EPC STORMWATER REVIEW COMMENTS
IN ORANGE BOXES WITH BLACK TEXT

VOLLMER ROAD (BARBARICK) - INTERIM CONDITION

GRADING AND EROSION CONTROL PLANS

VOLLMER ROAD (BARBARICK)
 -INTERIM CONDITION
 INITIAL/INTERIM GESC

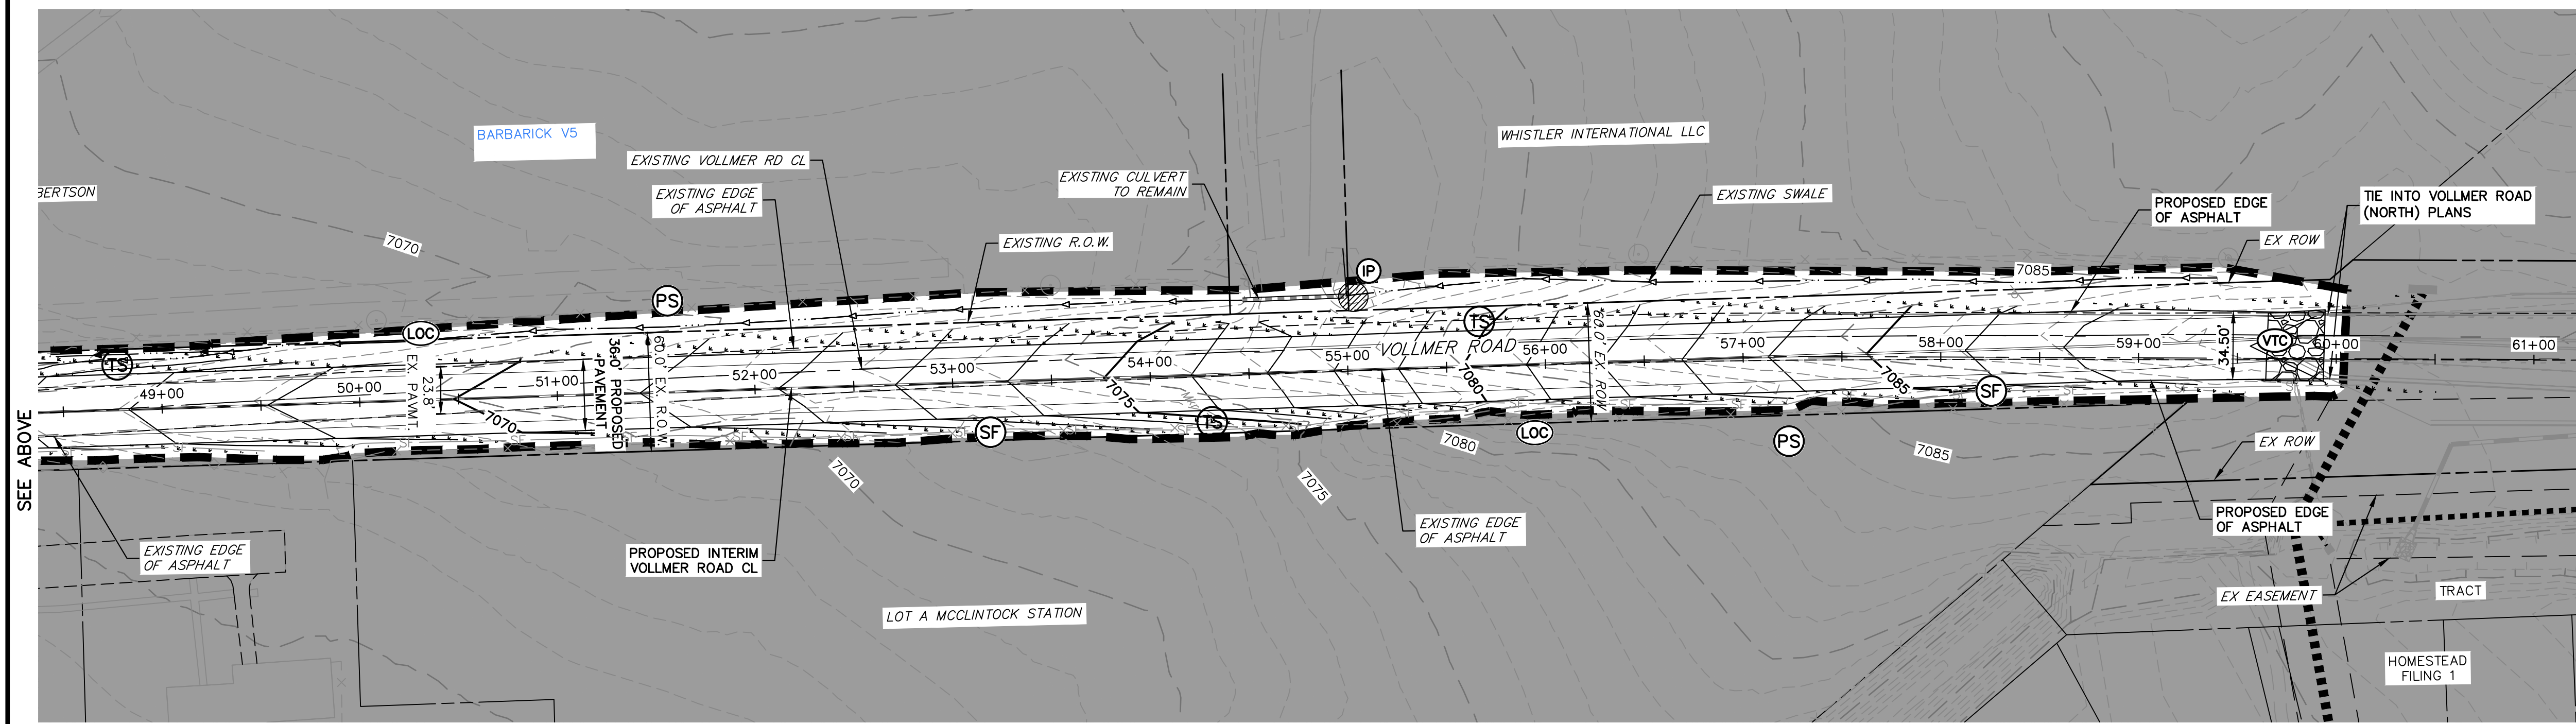
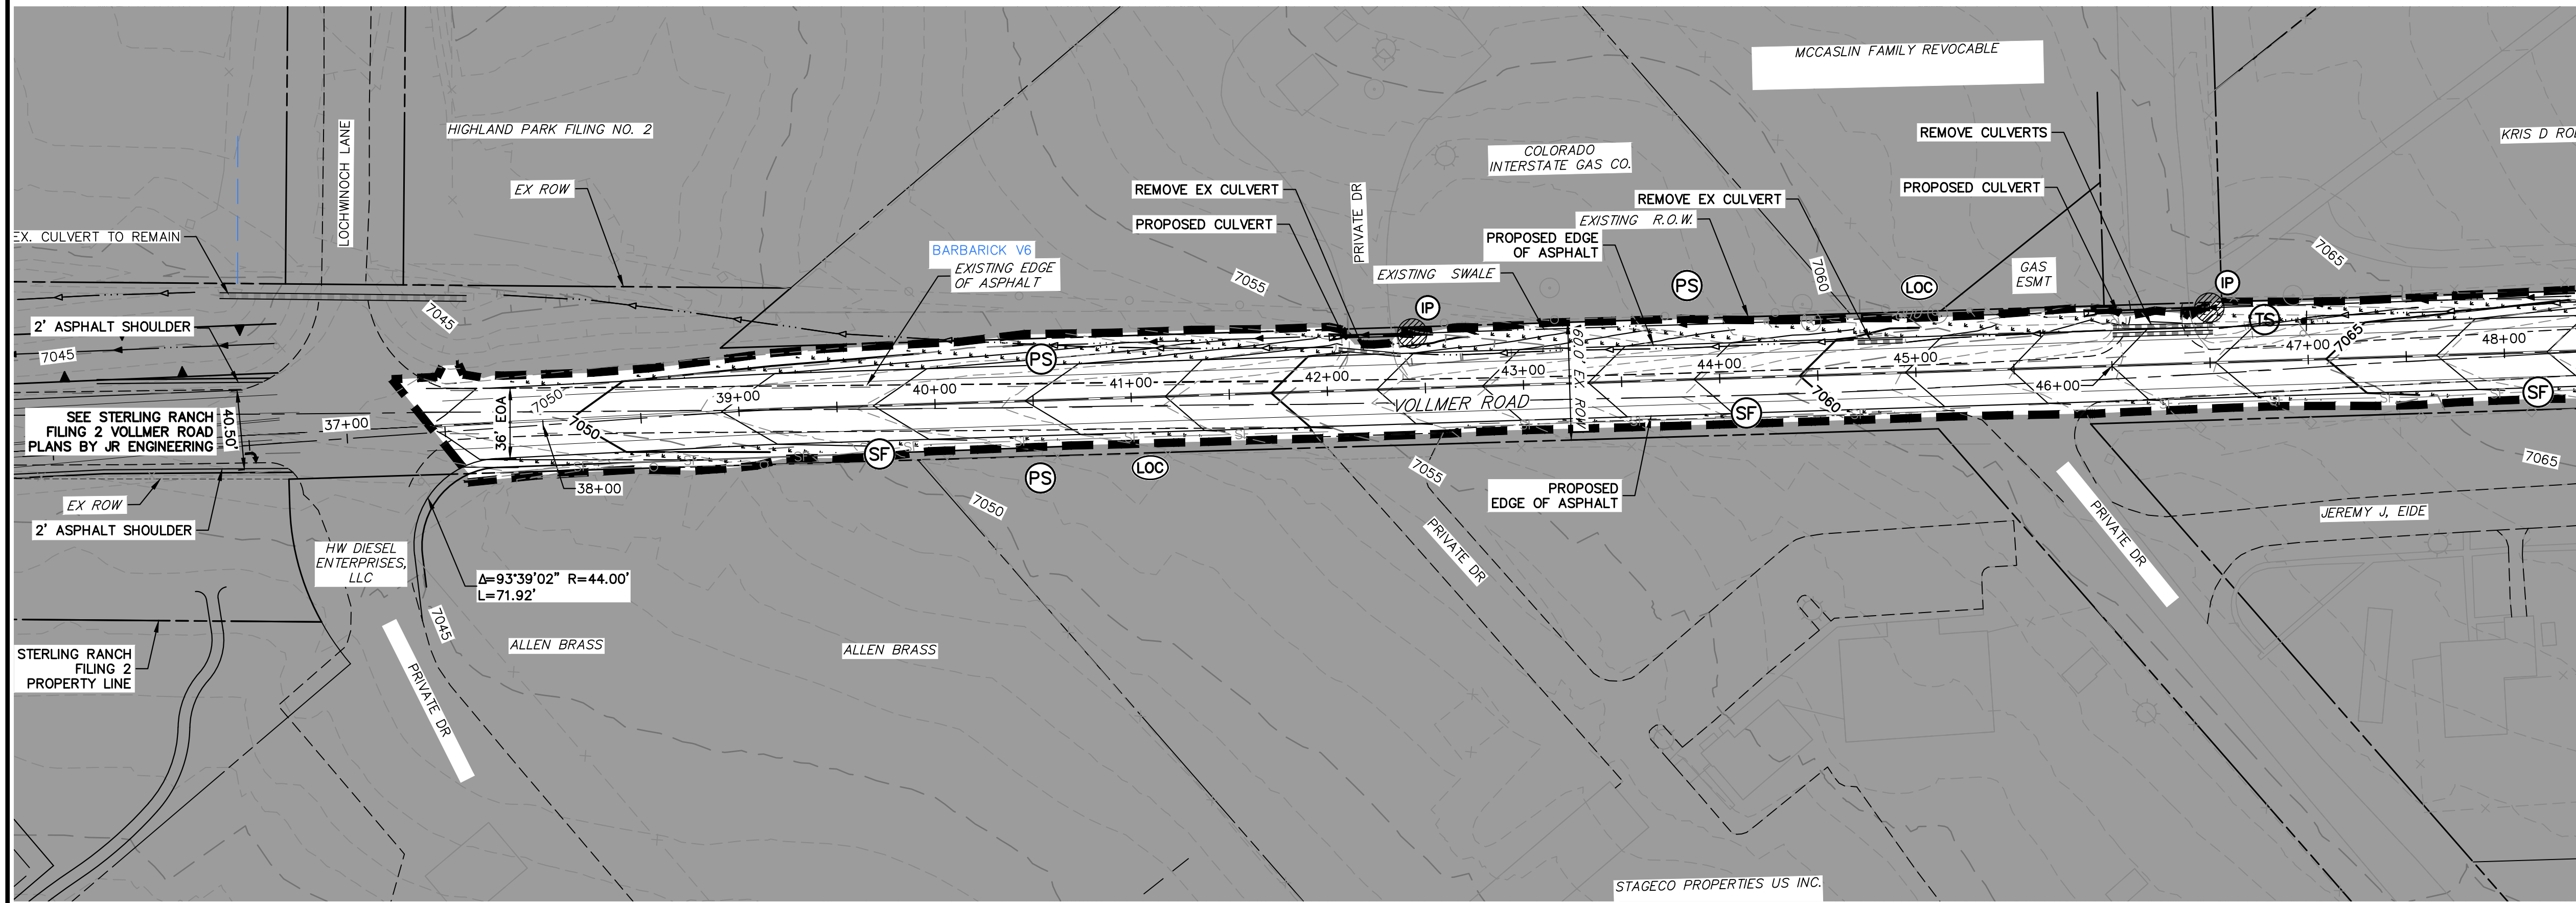
SWMP stated a different percent. Verify and update so both match.

GEC Checklist Item g: Show all existing utilities.

Add construction marker symbol and description to legend per the SWMP text.

show concrete washout
